File Number: 2016/248569
Our Ref: R/2014/33/C

RE: Response to Submissions - Modification to Concept Plan (MP06_0171 MOD 12) and Block 4N (SSD 6673 MOD 1) Central Park, Chippendale

REVIEW OF RESPONSE TO SUBMISSIONS

Block 4N Hotel Level H13 / Residential Level 11 FFL +57.90
Project No. 2094 Scale @ A0 1:200 Date 02/10/14 Drawn By GM
Number PA-A4-1768 Revision 01

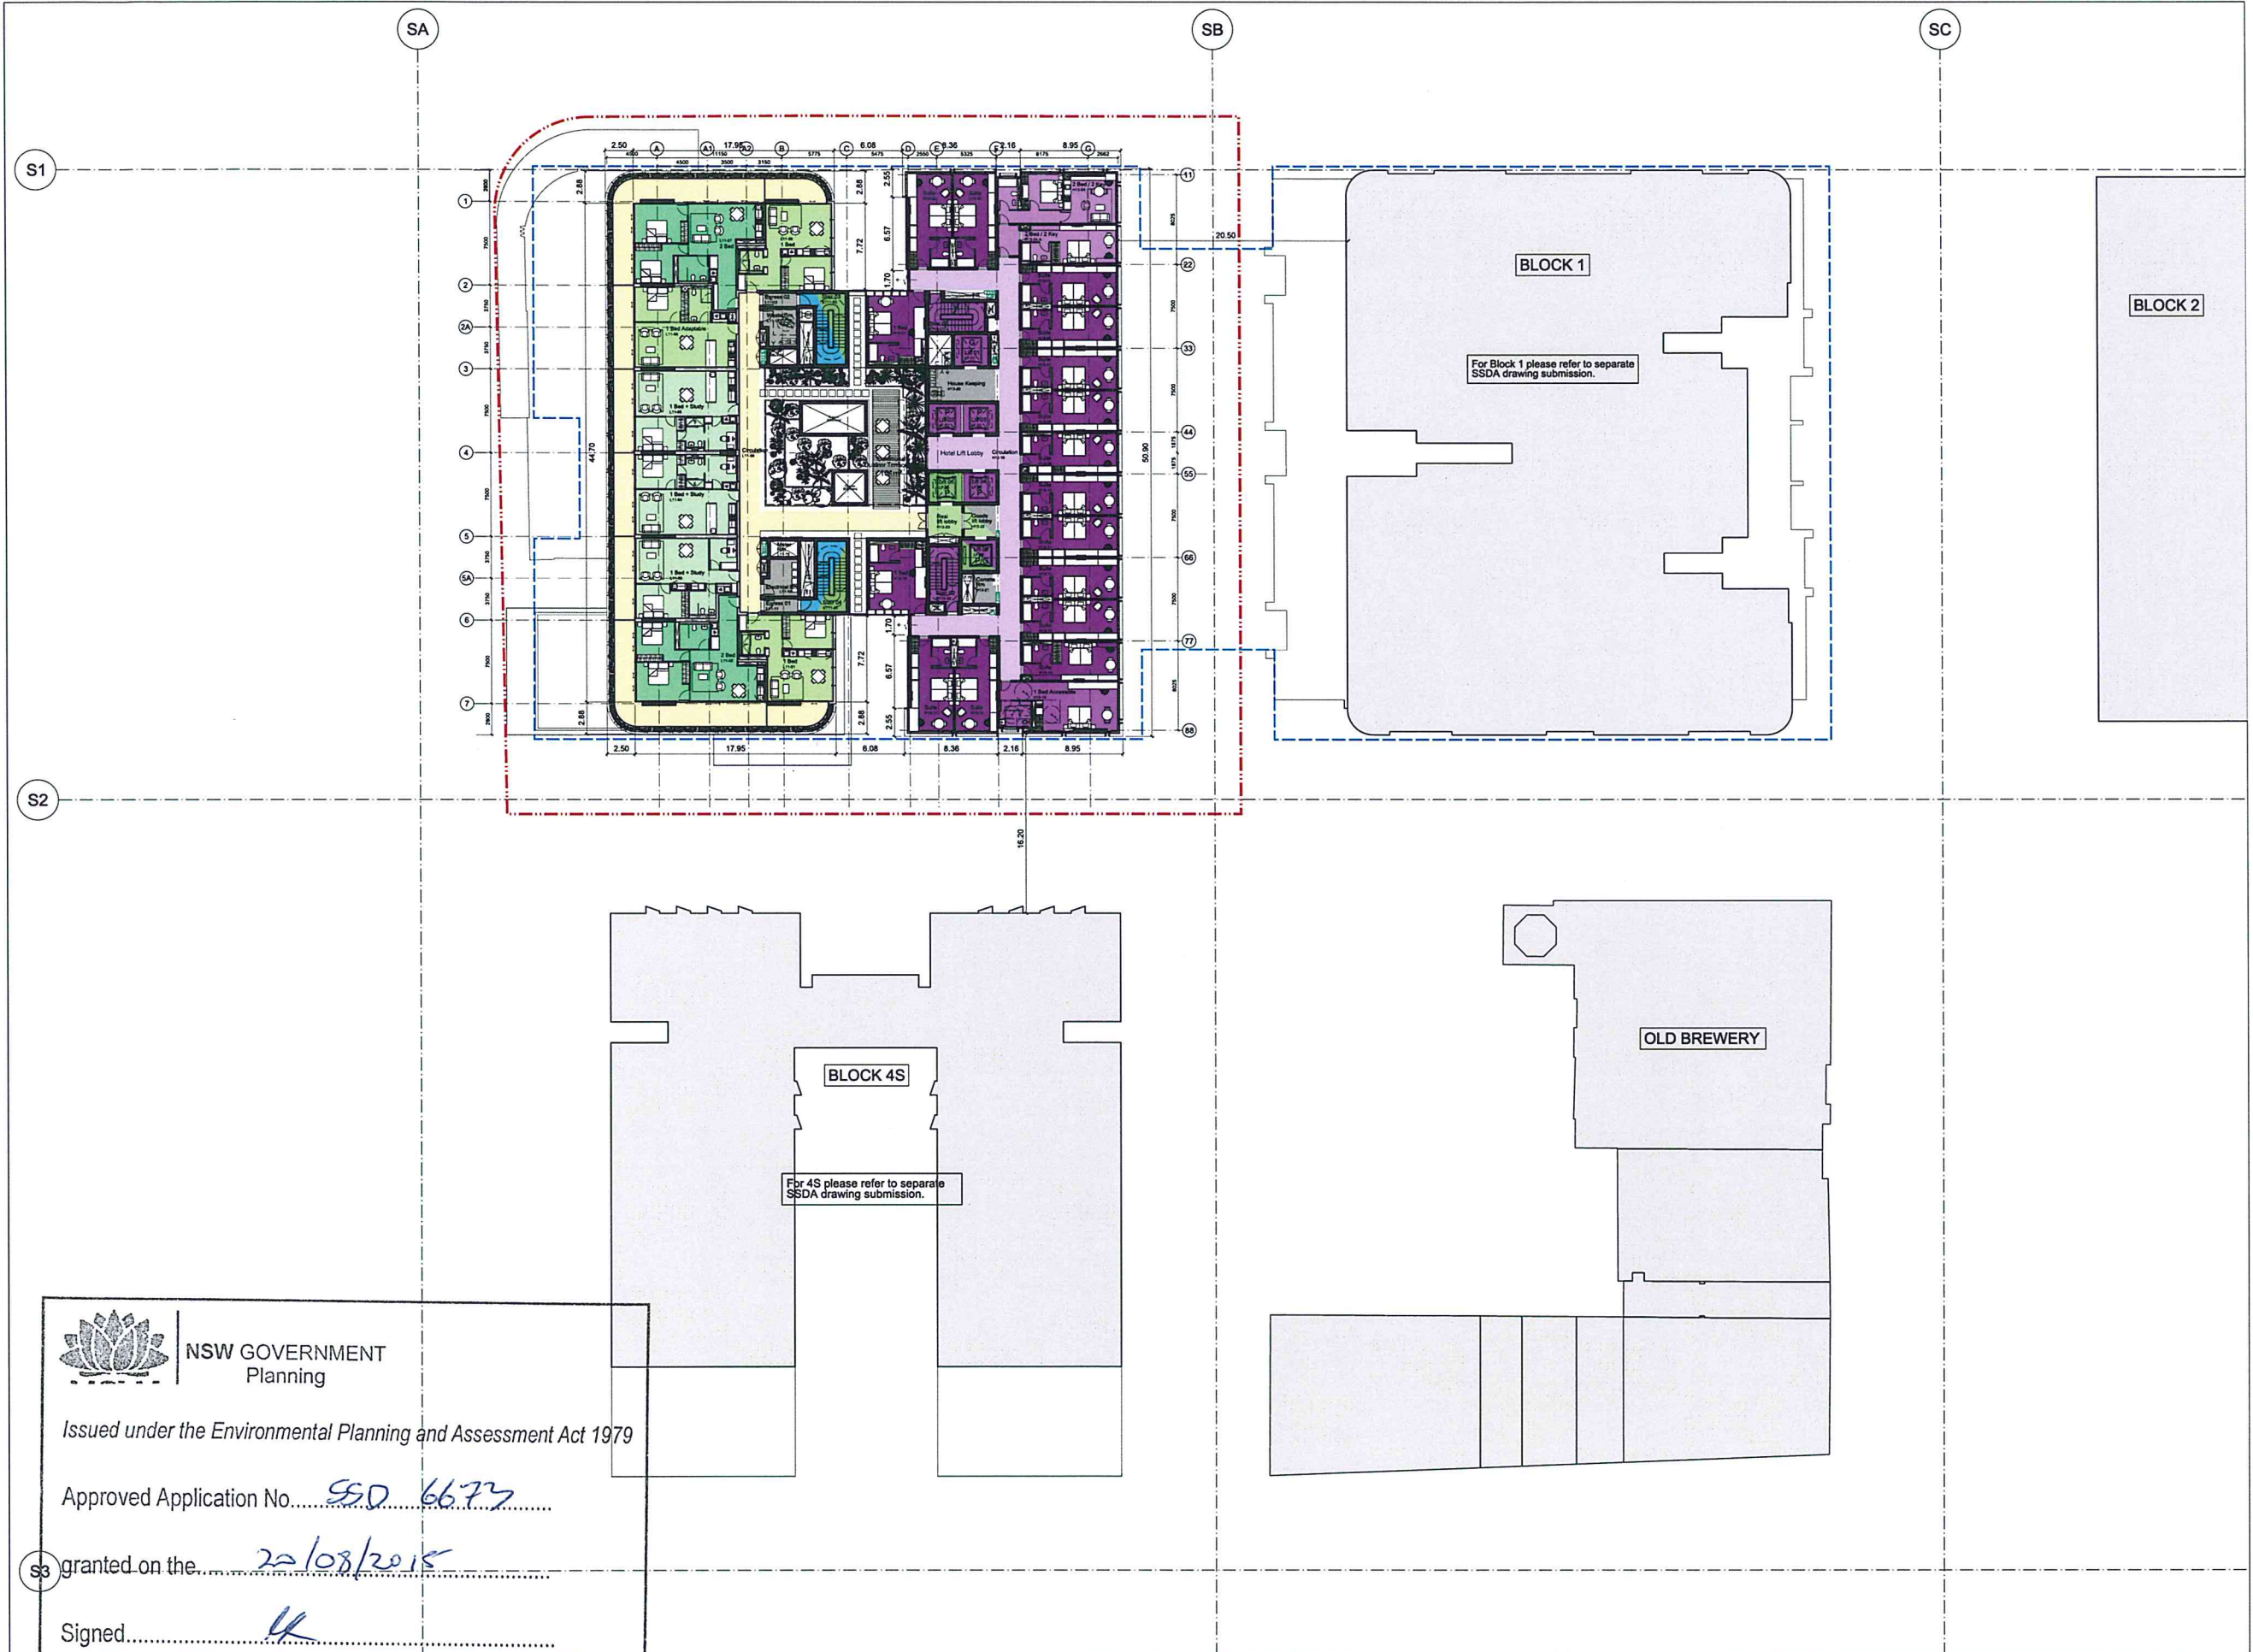
Internal Modifications to Residential			
The Environmental Assessment report states that no changes are proposed to the internal residential layout or apartment numbers on levels 4 to 18. However the Drawing List (PA-	Council have identified that amendments are shown on the residential levels and apartment typology plans. These modification	Partially	The Department should satisfy itself that the requirements of the ADG have been met.

Issue	Applicant's Response	Issue Addressed?	City's Contention
<p>A4-1010) indicates that modifications have been made to Residential Levels 13 to 18 (PA-A4-1768 to PA-A4-1773) and Apartment Typology Plans (PA-A4-1795 to PA-A4-1794). Clarification is required as to whether any internal modifications are proposed to residential floor space and if so, if there is any reduction in level of compliance with the Apartment Design Guide, including but not limited to changes to minimum apartment and room sizes and provision of solar access and natural cross ventilation.</p>	<p>relate to minor internal apartment configuration. They do not change the internal or external area, unit mix, or amenity of any apartments. The modifications include internal changes such as:</p> <ul style="list-style-type: none"> • minor shifts in riser locations due to ongoing services coordination with services engineers; • reconfiguration of some internal bathroom layouts due to ongoing design coordination; • minor adjustments to kitchen design due to ongoing design coordination; and • replacement of swing doors with sliding cavity doors to certain areas within the apartments.

Title
Block 4N
Landscaping

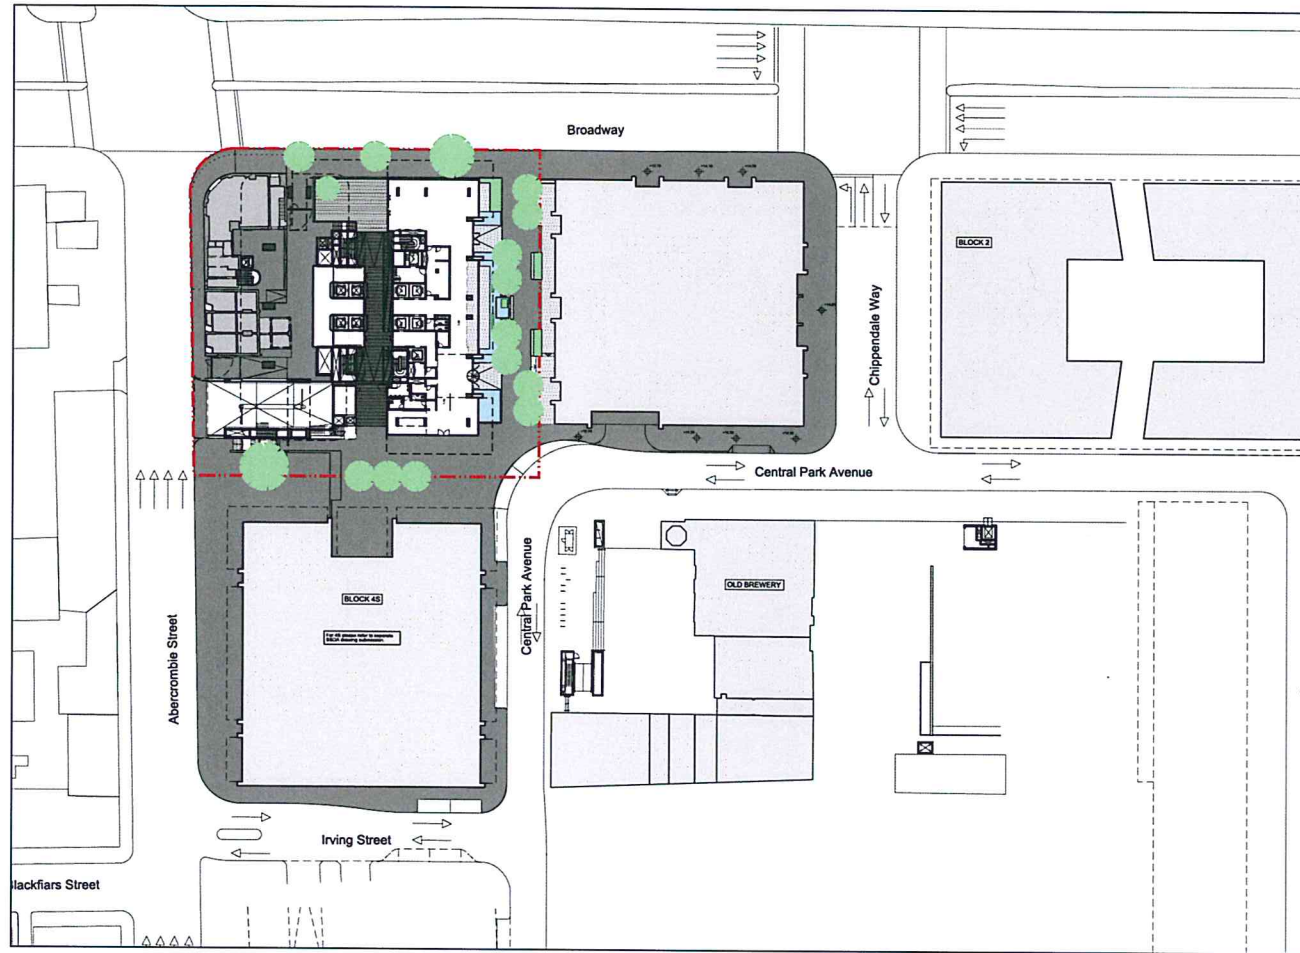
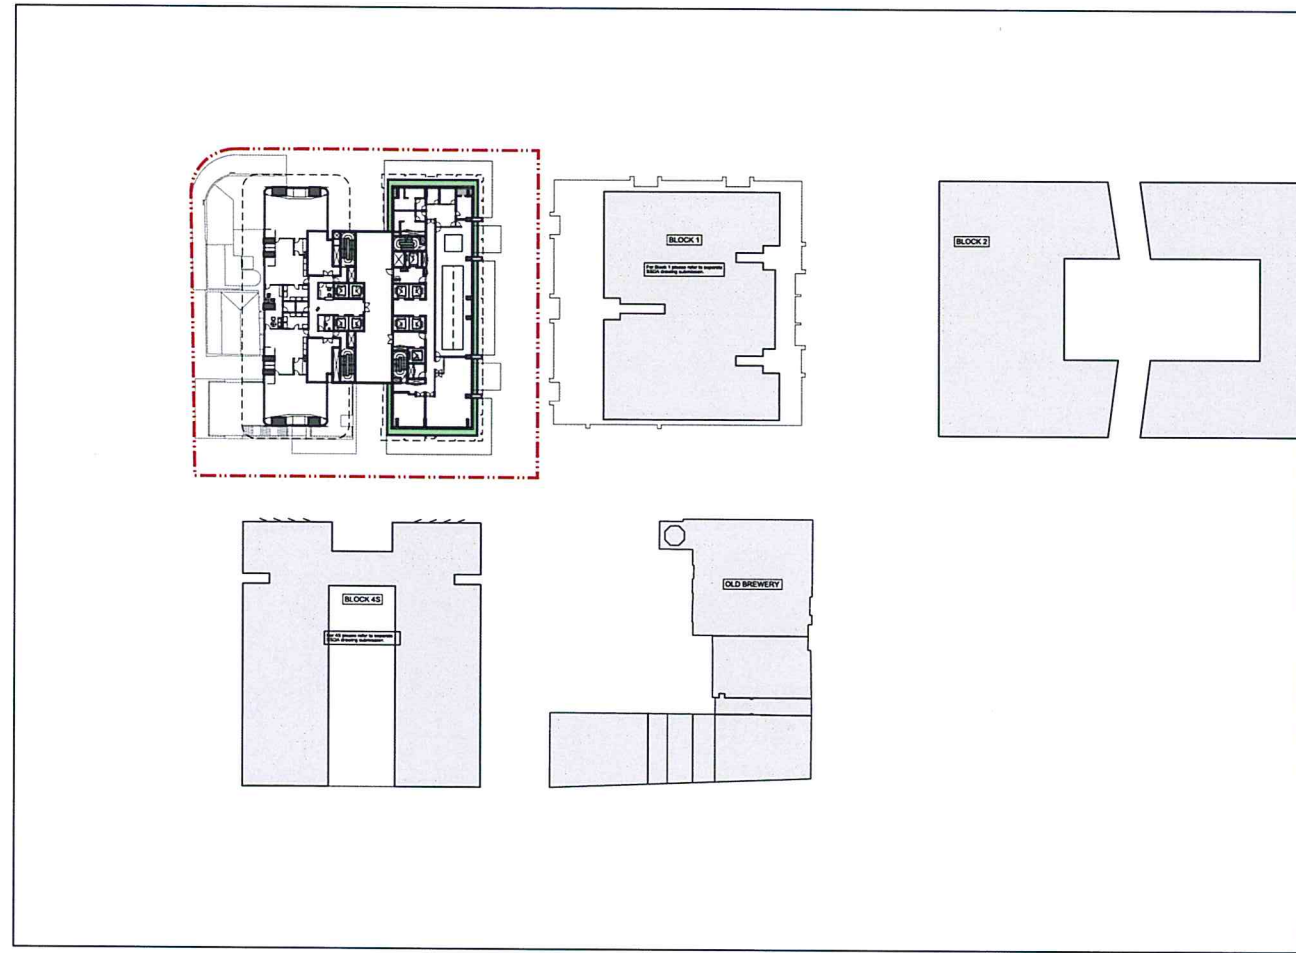
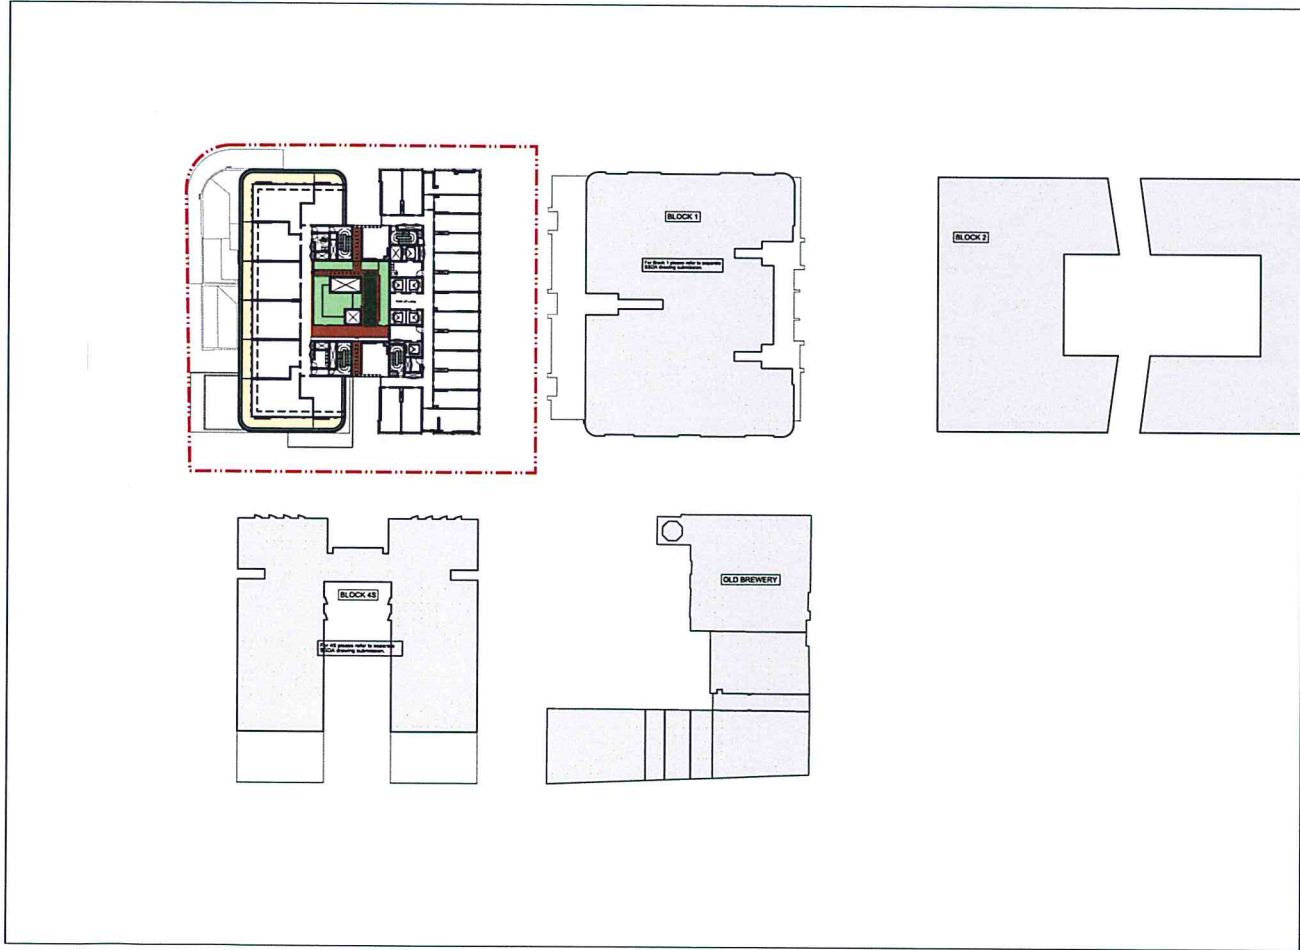
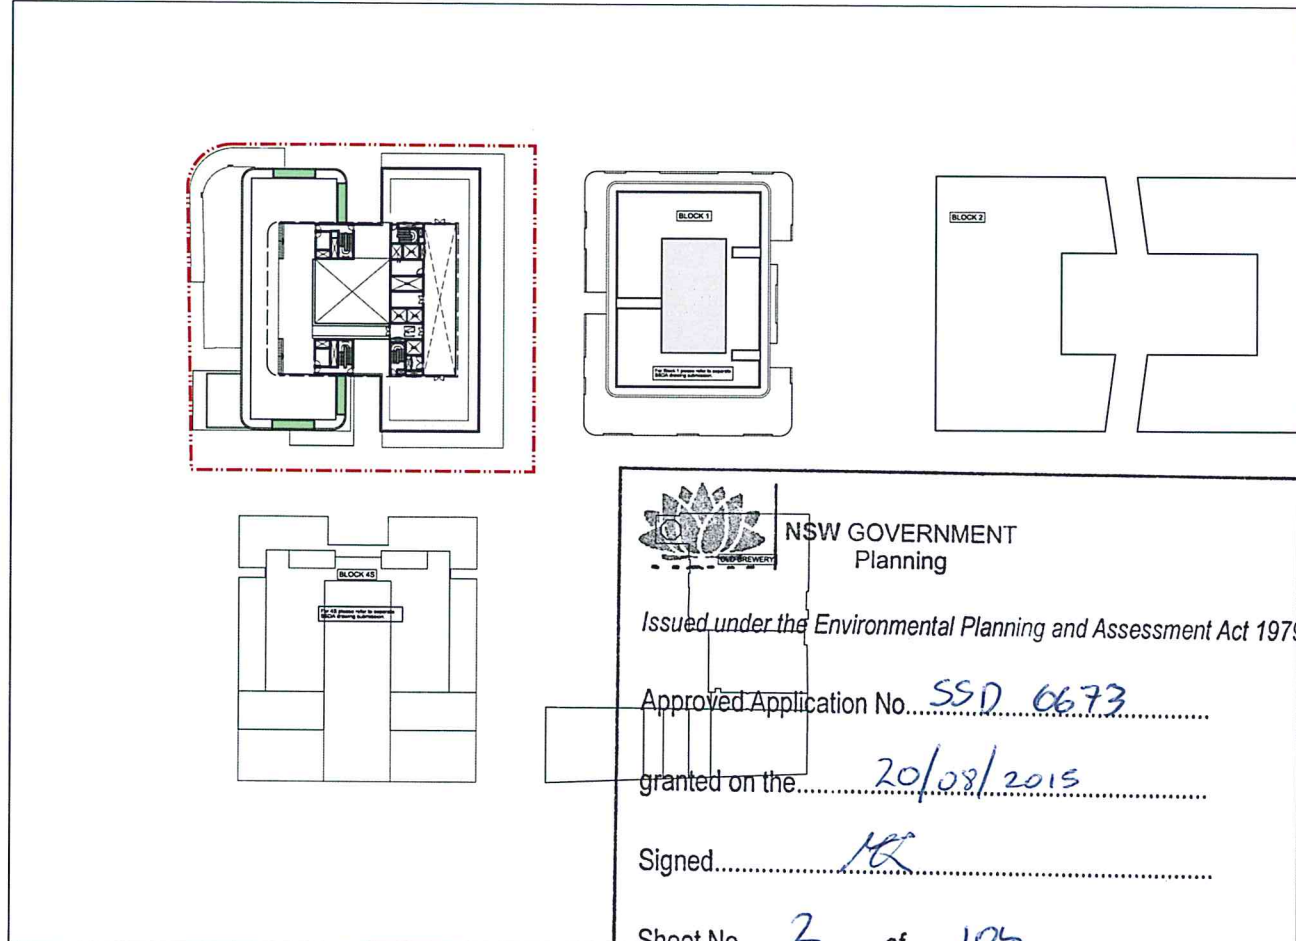
<p>The removal of the originally proposed water features is regrettable. While the proposal seeks to replace these features with planting, the retention of the water features is recommended.</p>	<p>The revised ground plane landscaping, has been modified proposing the removal of the water features which are proposed to be replaced with additional soft and hard landscaping and planters, including the extent of planter boxes. The additional planters also allow for a greater level of public access through the pedestrian link and</p>	No	<p>The City's concerns remain unaddressed.</p> <p>The City's original comments remain unchanged.</p>
